YorkshireWater

4th August 2025

**The Laurels, Viewlands, Silkstone, Barnsley S75 4QP – Pre-Planning Sewerage Enquiry
X003346**

Status:	FOR APPROVAL
Project:	THE LAURELS
Title:	DRAINAGE PLAN
Date:	03/07/2025
Scale:	1/200 @ A1
Job No: 480	Drg No: 001 Rev C

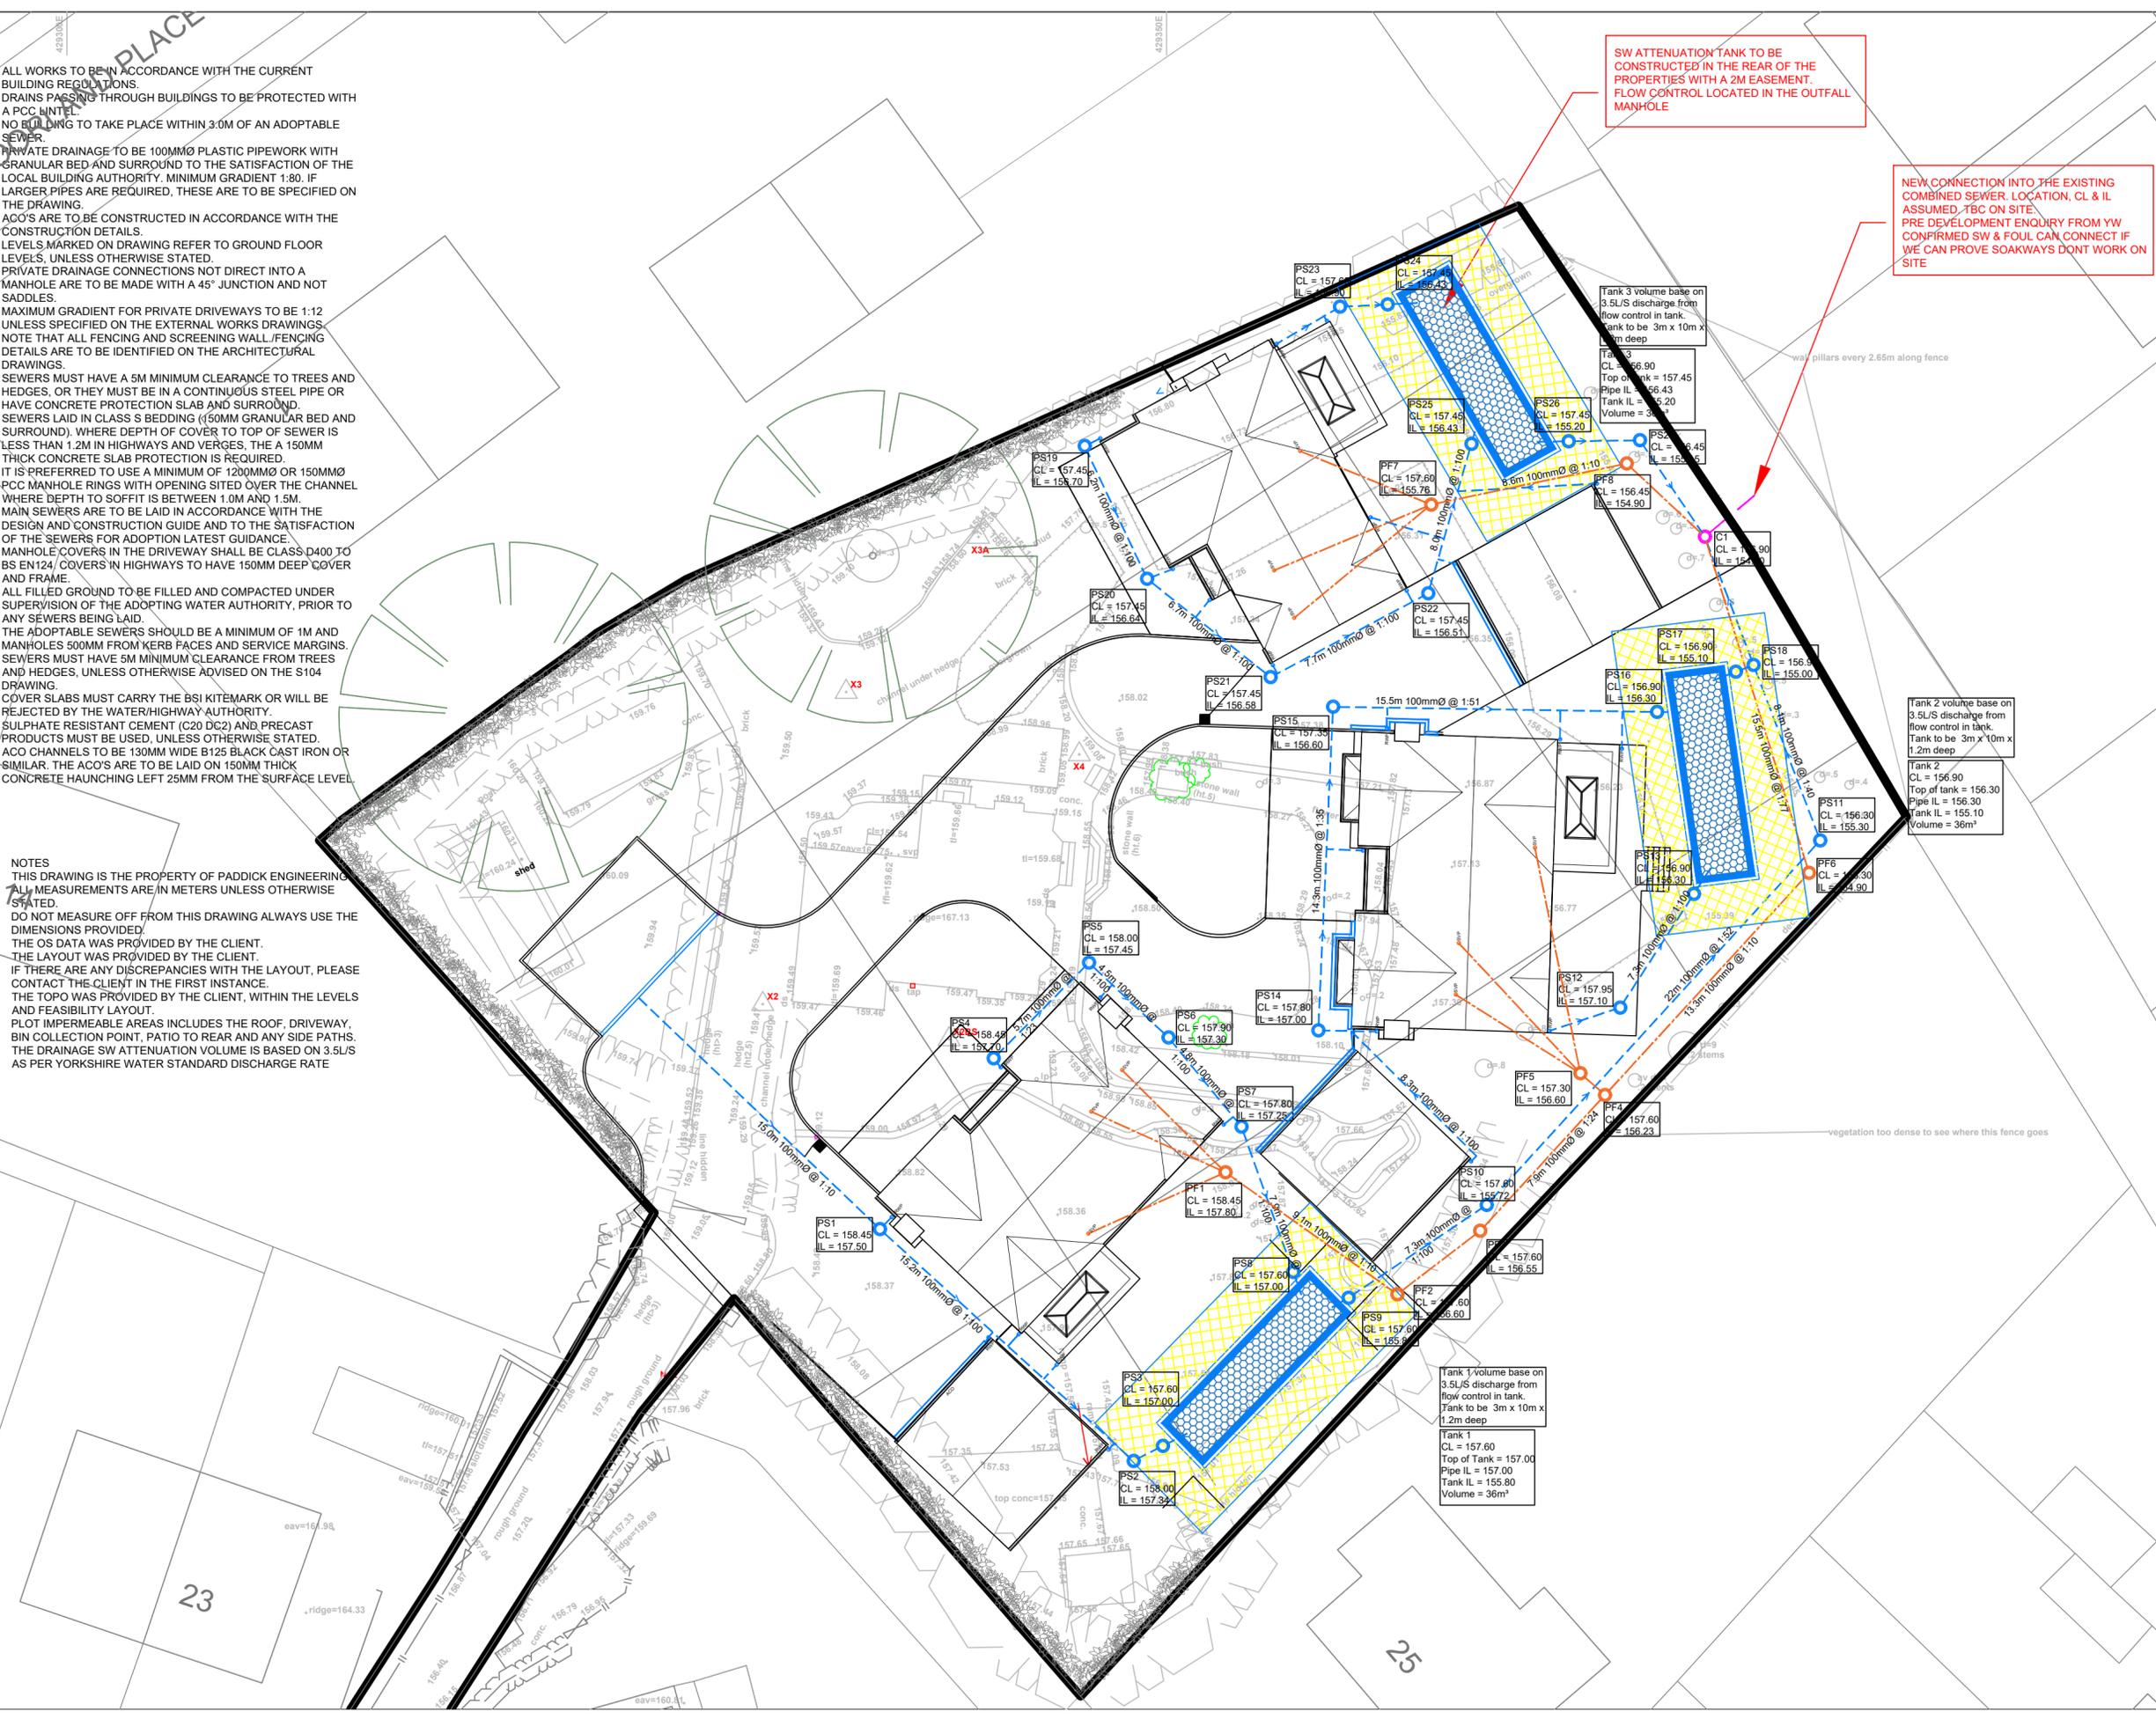
There is a 180mm diameter public combined rising main recorded on the access road to the east of the site. While this rising main is not affected by the on-site works, it is noted from application details that the existing combined water connection for the site is to be diverted. Given the combined diversion will take place in the vicinity of the rising main, the main should be surveyed, and adequate measure put in place to avoid damaging it.

Foul water may discharge to the existing combined water connection. This permission is not an acceptance in respect to any planning conditions imposed under the Grant of Planning Permission.

As a last resort and subject to providing satisfactory evidence as to why the other methods of surface water disposal have been discounted, curtilage surface water may discharge to the existing combined water connection for the site at a rate not to exceed 3.5 litres per second. This permission is not an acceptance in respect to any planning conditions imposed under the Grant of Planning Permission.
